Application by Highways England for the A303 Sparkford to Ilchester Dualling project
The Examining Authority's written questions and requests for information (ExQ1)
Issued on 20 December 2018

ExQ1	Question to:	Question:	SSDC Response
1.0	General and Cross-topic Questions		
1.0.2	SSDC	<p>Local Plan</p> <p>a) While various policies of the South Somerset Local Plan (2006 – 2028) have been cited by the Applicant, could the Council please provide a copy of the complete document and any associated policies map(s)?</p> <p>b) The Case for the Scheme [APP-149, paragraph 7.4.10] indicates that the Local Plan is currently being reviewed. Could the Council please indicate the latest situation, provide updated information as appropriate and advise what, if any, weight it considers should be given to this emerging Local Plan?</p>	<p>a) The adopted Local Plan and associated maps can be found here: https://www.southsomerset.gov.uk/planning-and-building-control/spatial-policy/south-somerset-local-plan-2006-2028/adopted-south-somerset-local-plan/ Should the ExA require a hard copy of these documents, please contact the District Council -</p> <p>b) The emerging Local Plan is being reviewed. The Issu

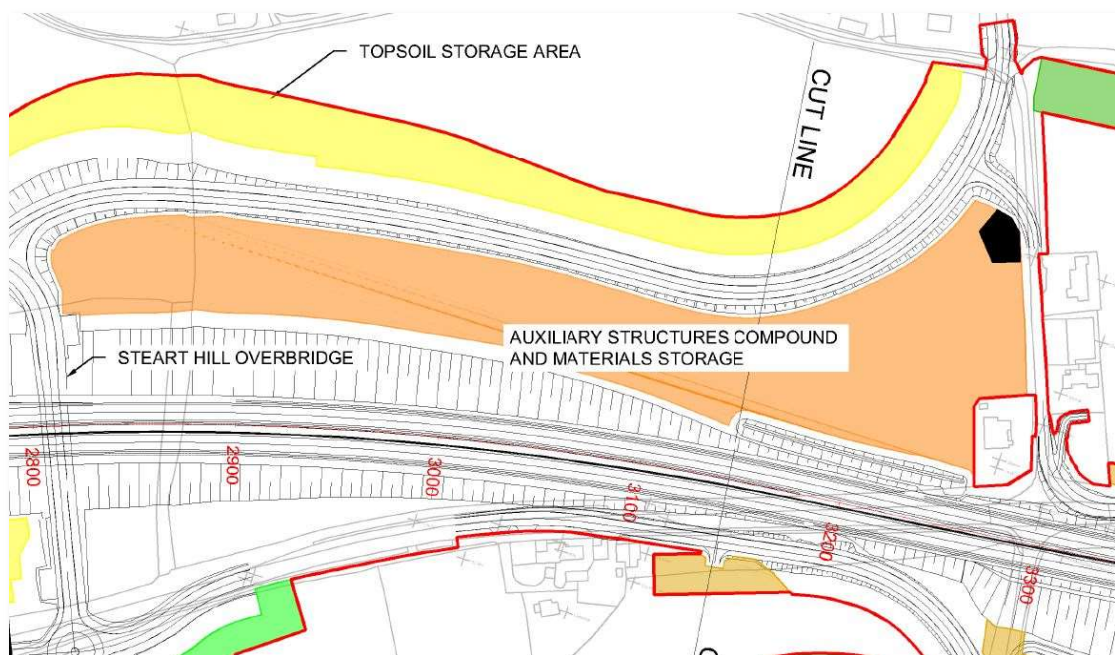
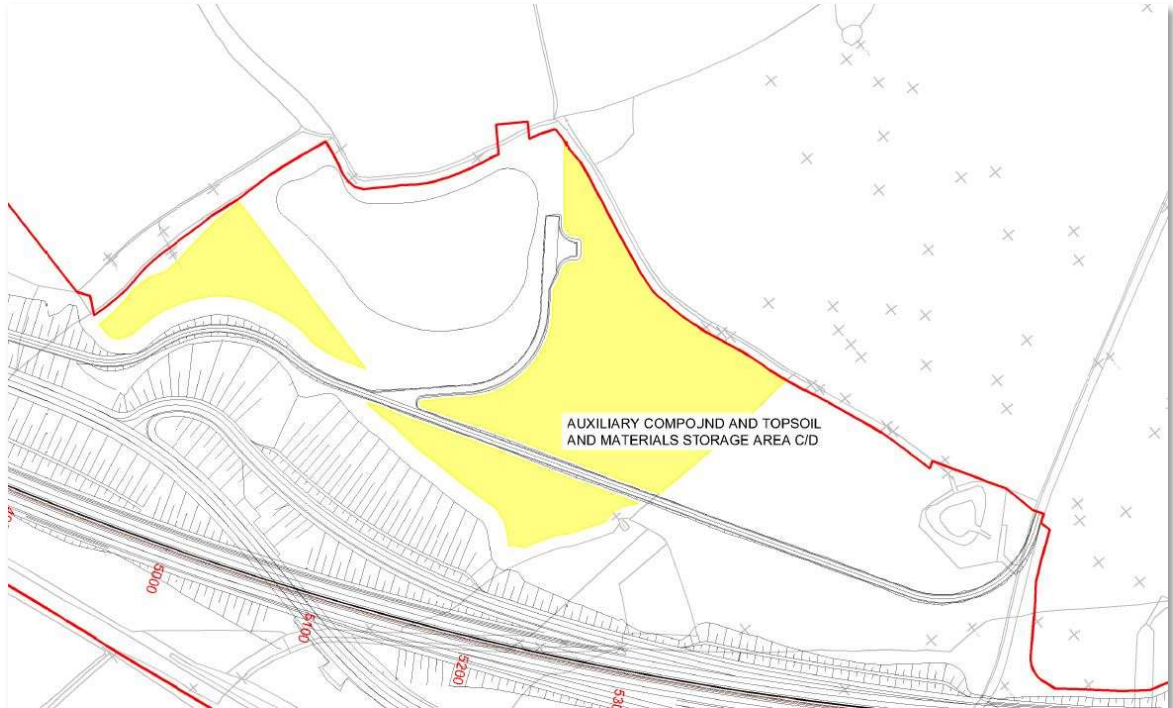
1.1.19	The Applicant SSDC Historic England	Hazlegrove House RPG a) In Table 6.4, second row, of the Chapter 6 Cultural Heritage of the ES [APP-043] assessing the effects on the Hazlegrove House RPG there are references to a "construction compound" and an "ancillary construction compound". However, these are not shown on the works plan. Have they been omitted from the works plan or no longer proposed? b) Does the assessment set out in the ES need to be updated to take account of the final proposal?	a) A construction compound is understood to be proposed in the RPG, as illustrated in Figure 2.25 of Chapter 2, page 56. b) The ES does not include the impact of the construction compound on the retention, or not, of veteran trees. The ES should consider the impact of the construction compound on the veteran trees. The same is true for aspects of the proposed works in close proximity to the veteran trees of the RPG. Paragraph 6.6.4 of the DBA identifies five veteran trees in the southern end of the RPG. Appendix C of the DBA includes a plan with three other 'additional trees of interest' in this area. Six of these eight trees would likely be affected by the scheme through the construction compound, drive realignment and land take. Paragraph 7.4.3 of the DBA states that "An arboricultural survey has been undertaken for the area of the park within the redline boundary of the scheme. Once findings have been collated and reporting completed, the results could help to inform a better understanding of the historic importance of the trees within the southern end of the park. Findings will be incorporated into the final version of this report". The findings of the survey and an assessment of the impact of the scheme on these trees should be included in the ES.
